**23 Ocean Avenue – 4 residential units, app. 2,400 SF office**

**LEVEL III SITE PLAN REVIEW (14-526)**

REINFORCED CONCRETE SIDEWALK
NOT TO SCALE

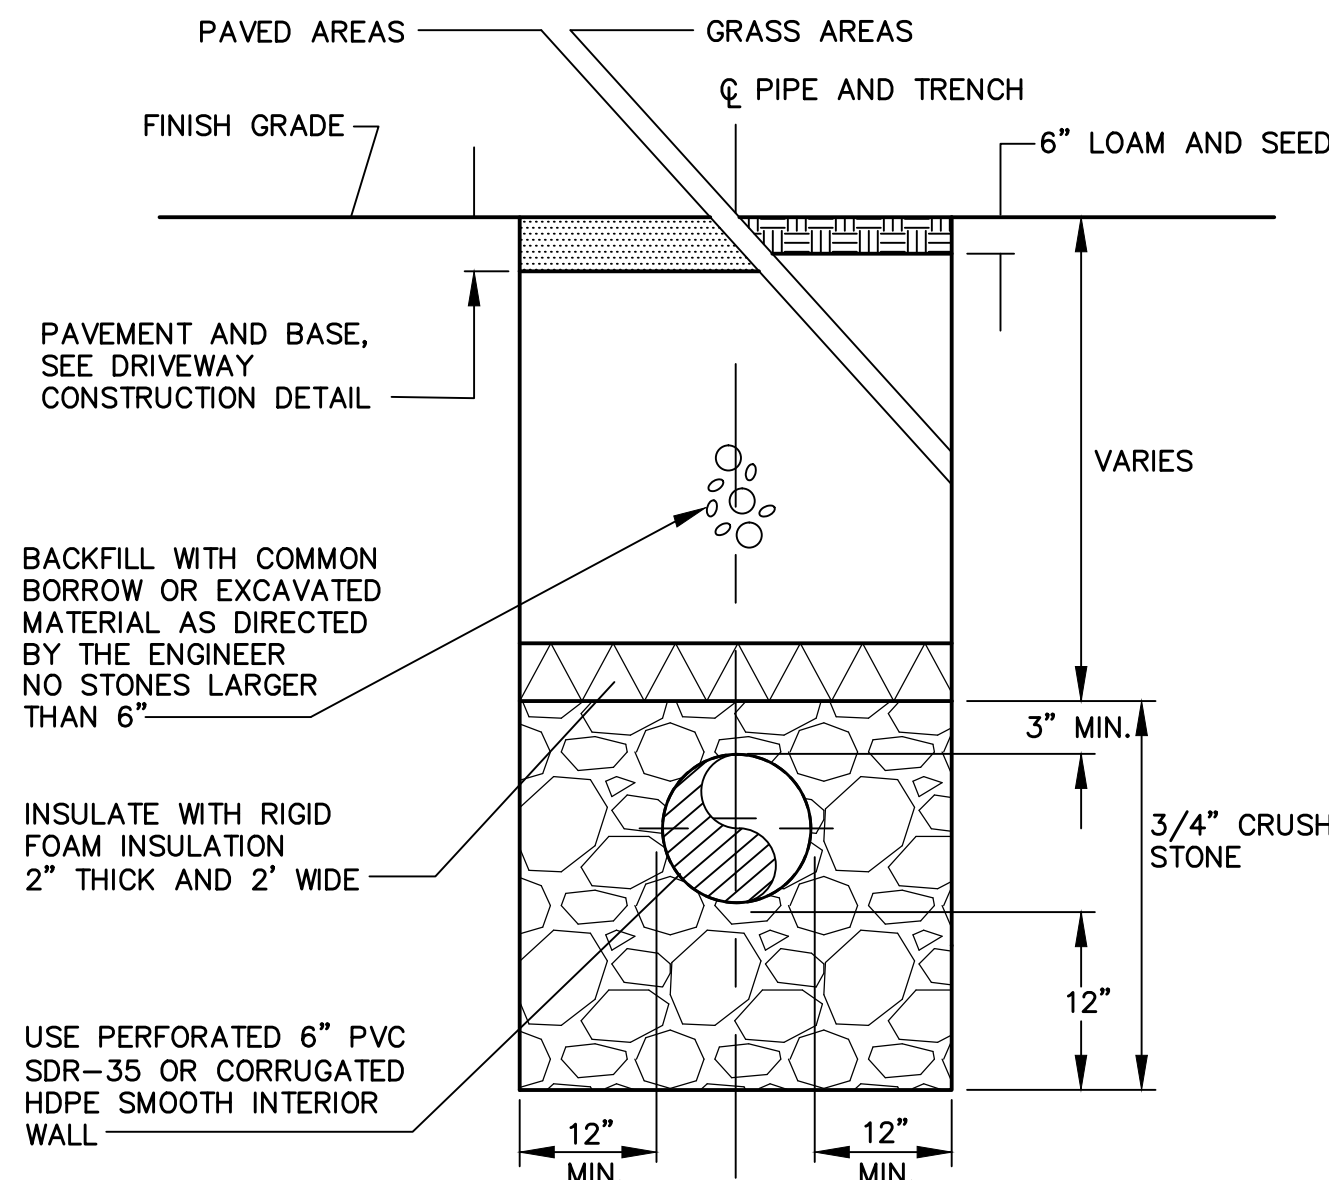
Preliminary Review
<b>Transportation</b>	a. Impact on Surrounding Street Systems	•
	b. Access and Circulation	• Sidewalk should be reconstructed along entire length of Ocean Avenue frontage • Need documentation of ADA accessibility from the street

UNDERGROUND ELECTRIC/COMMUNICATIONS UTILITY TRENCH DETAIL
NOT TO SCALE

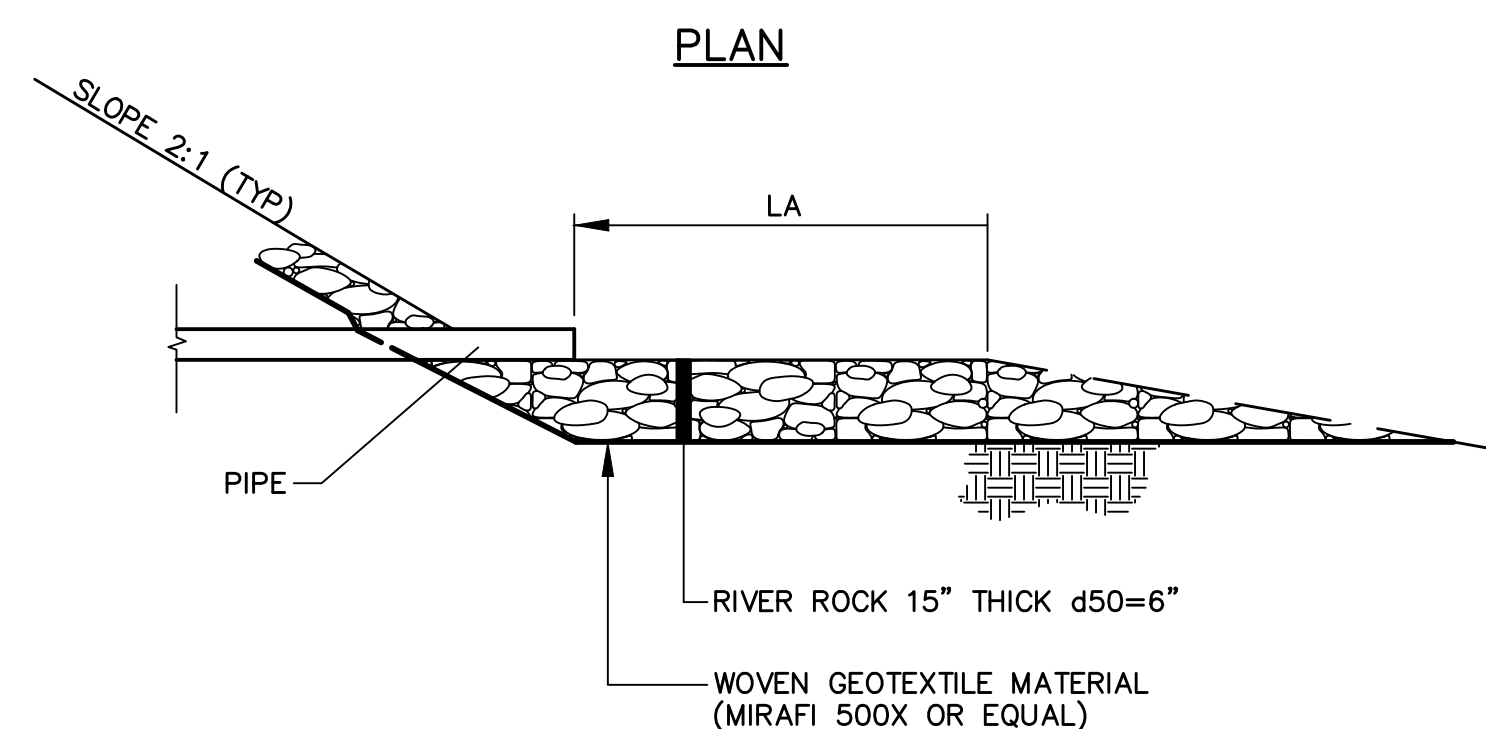
c. Availability and Adequate Capacity of Public Utilities	• Overhead electric is not permitted. Please confirm a plan for underground electrical with CMP and revise plans accordingly • Can the existing pole on Hersey Street be removed?
<b>Site Design</b>	a. Massing, Ventilation and Wind Impact	• Where is HVAC venting?
